**CITY OF PORTLAND, MAINE
DEVELOPMENT REVIEW APPLICATION
PLANNING DEPARTMENT PROCESSING FORM
DRC Copy**

Maggie Lane Lot # 21
Project Name/Description

RE: Lot 21 Maggie Lane
(ID#2001-0261, CBL#292-A-041)

CITY OF PORTLAND  
APPROVED SITE PLAN

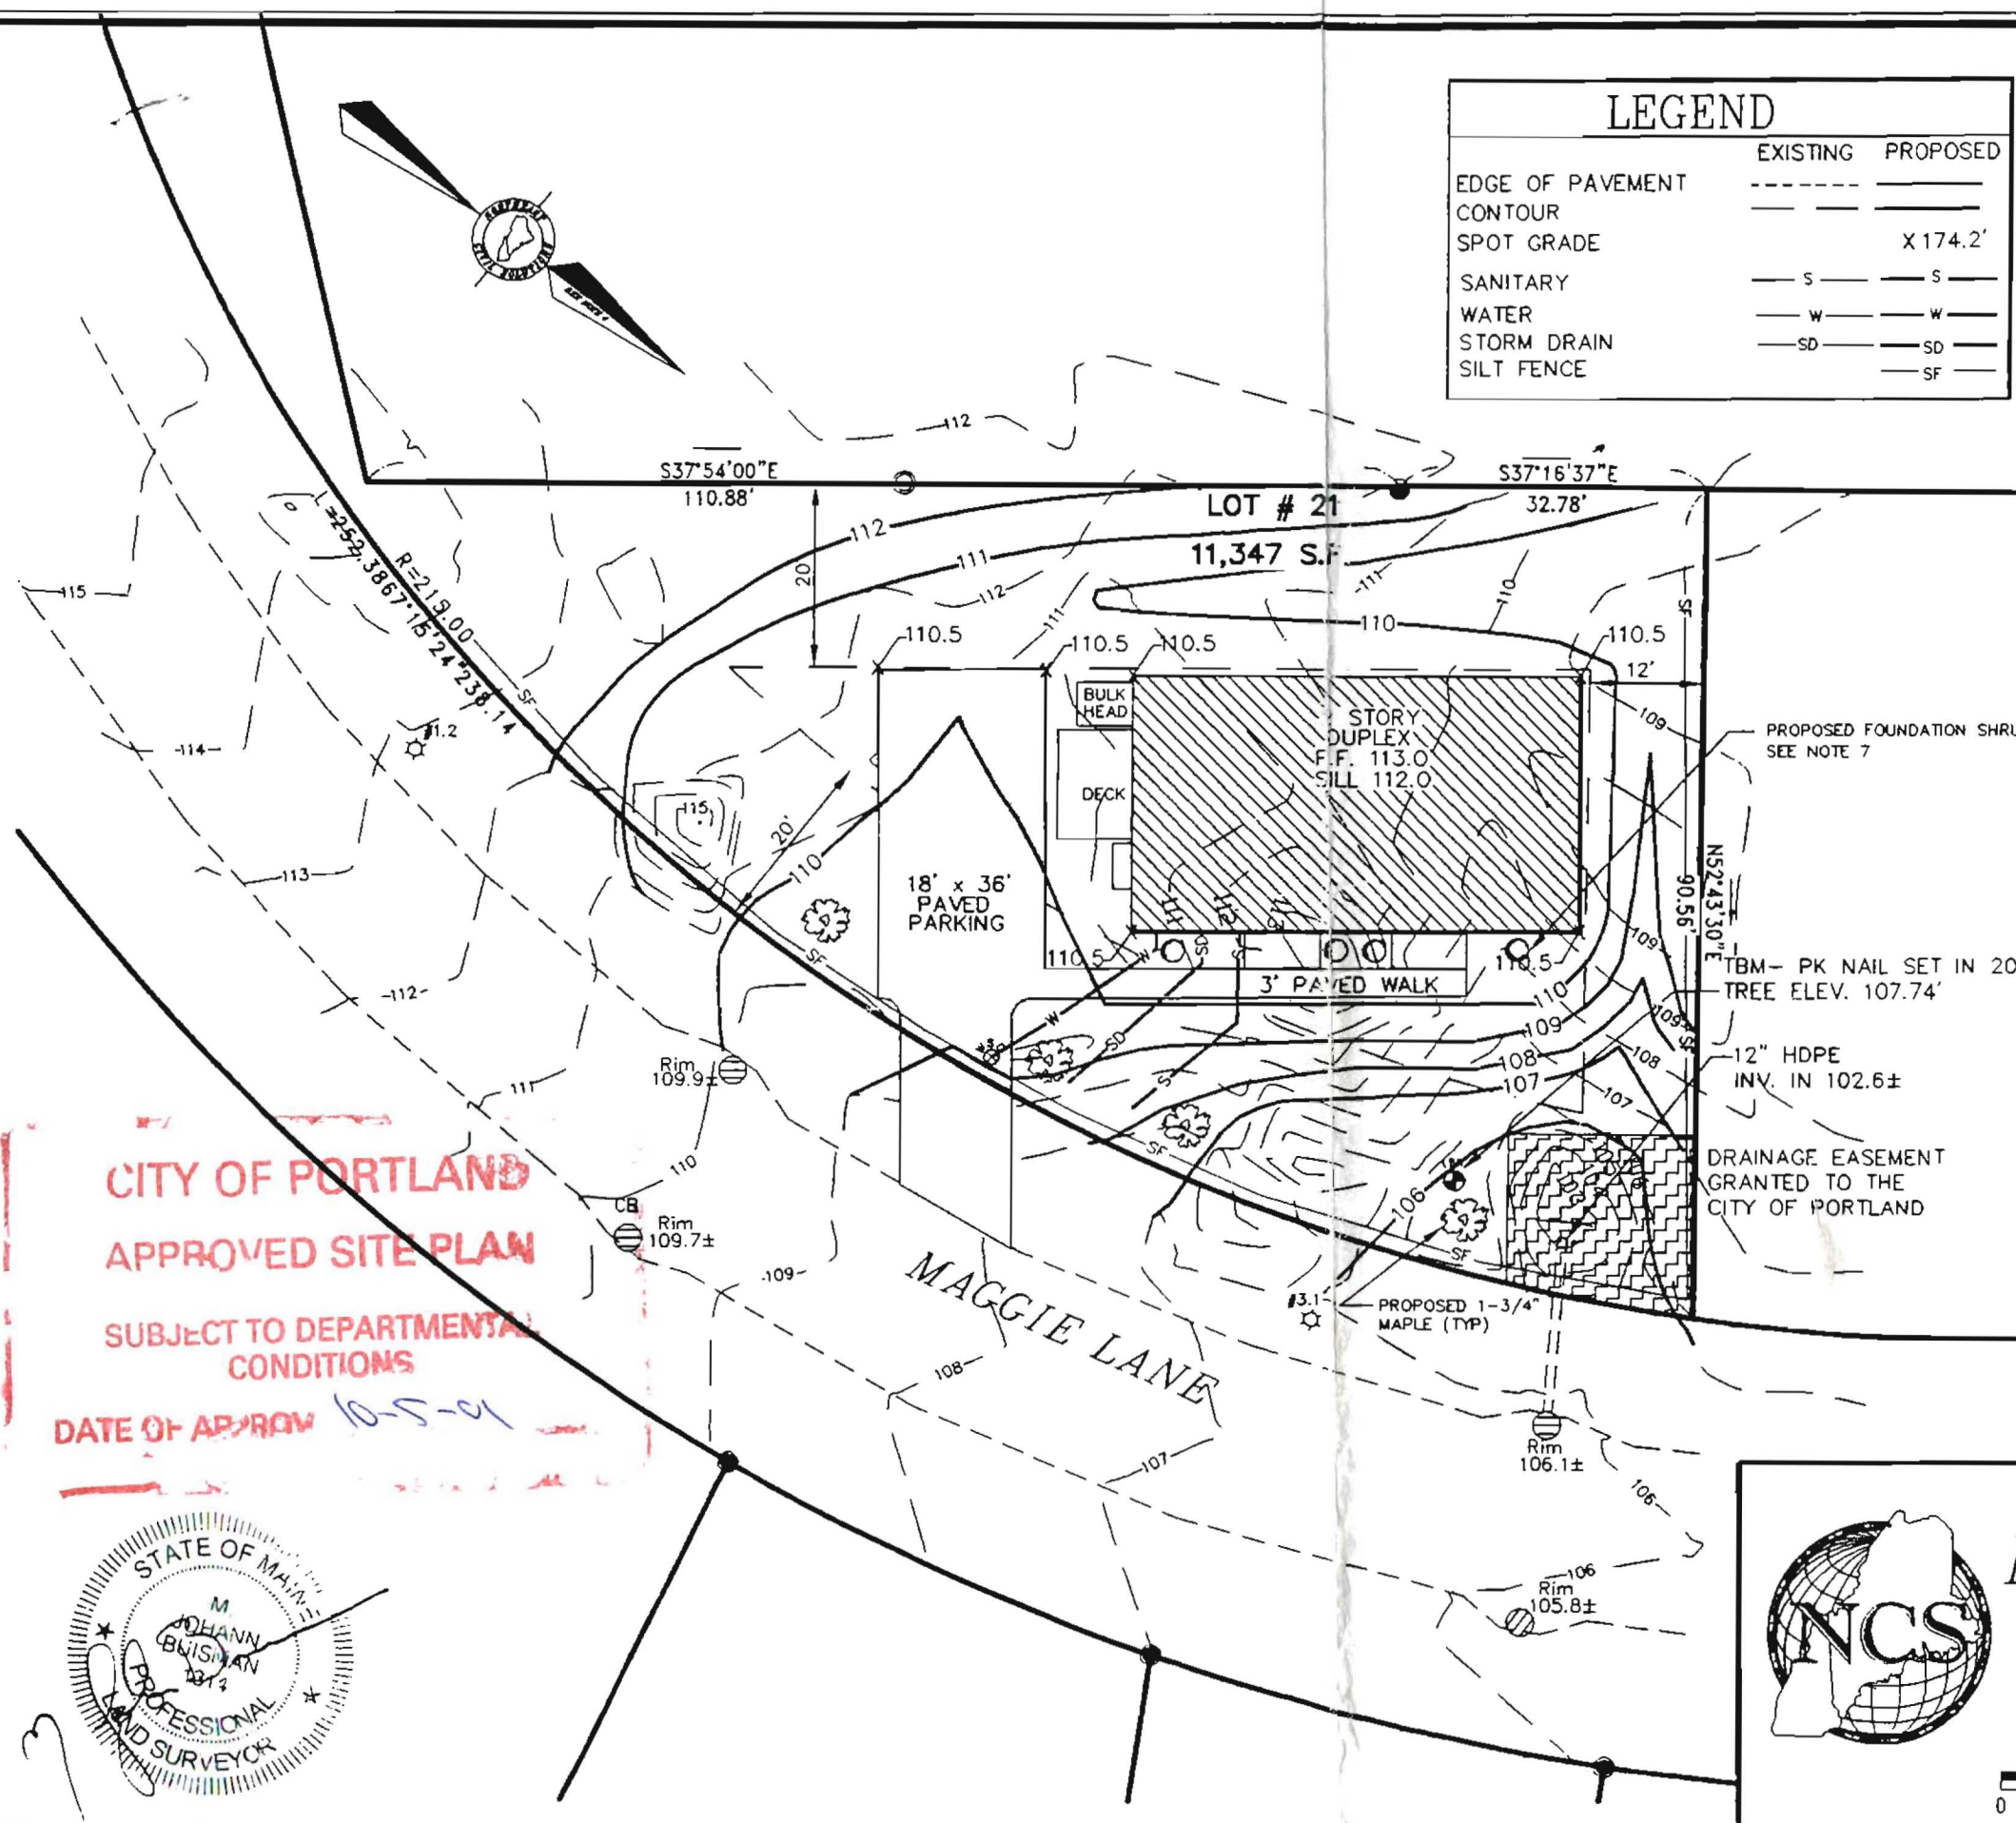
- 1 This permit is being approved on the basis of plans submitted. Any deviations shall require a separate approval before starting that work.
- 2 Separate permits shall be required for future decks, sheds, pools, and/or garage. Currently only an 8' x 12' left side deck is shown.
- 3 A daylight basement is not being shown and is therefore not being approved.
- 4 Your driveway pavement is required to be extended two (2) feet in order to accommodate 4 parking spaces that are 9' x 19'. That would mean the length of the parking area shall be 38' not 36'.
